## KITTITAS COUNTY COMMUNITY DEVELOPMENT SERVICES

May 26, 2017

RE: Shoreline Exemption SX-17-00011

**SITE PLAN**

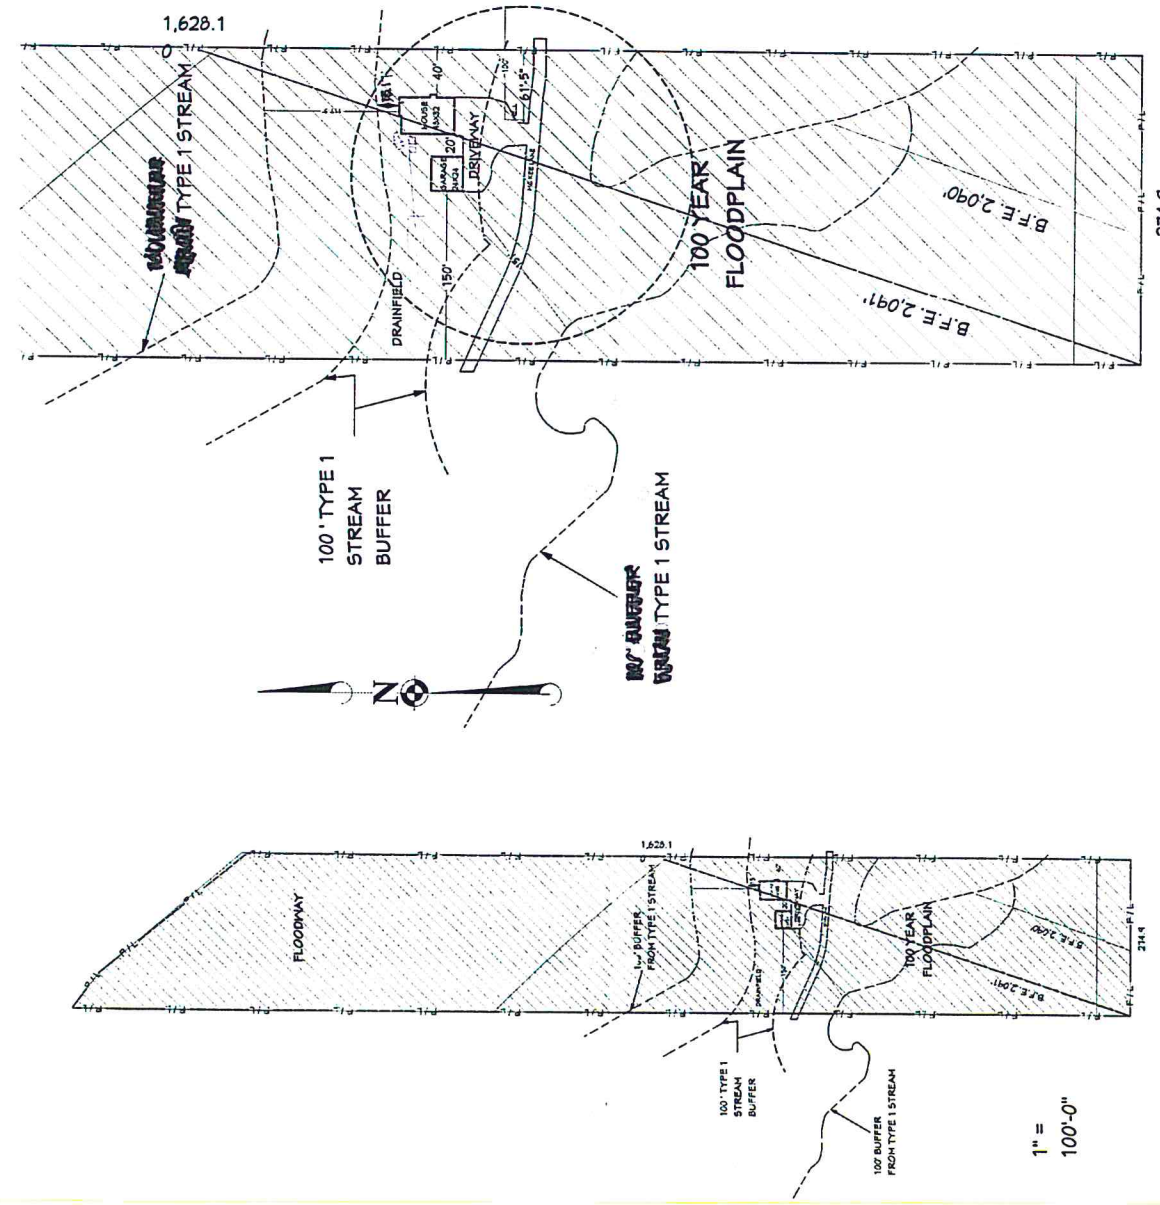
On May 22, 2017 Community Development Services received a Shoreline Exemption permit application for parcel number 16625. After an initial review, it has been determined that more information is needed before this application can be deemed complete and processed. Please provide an updated site plan with the following information:

- Scale
- Correct labeling of streams
- Location of septic tank and drain field
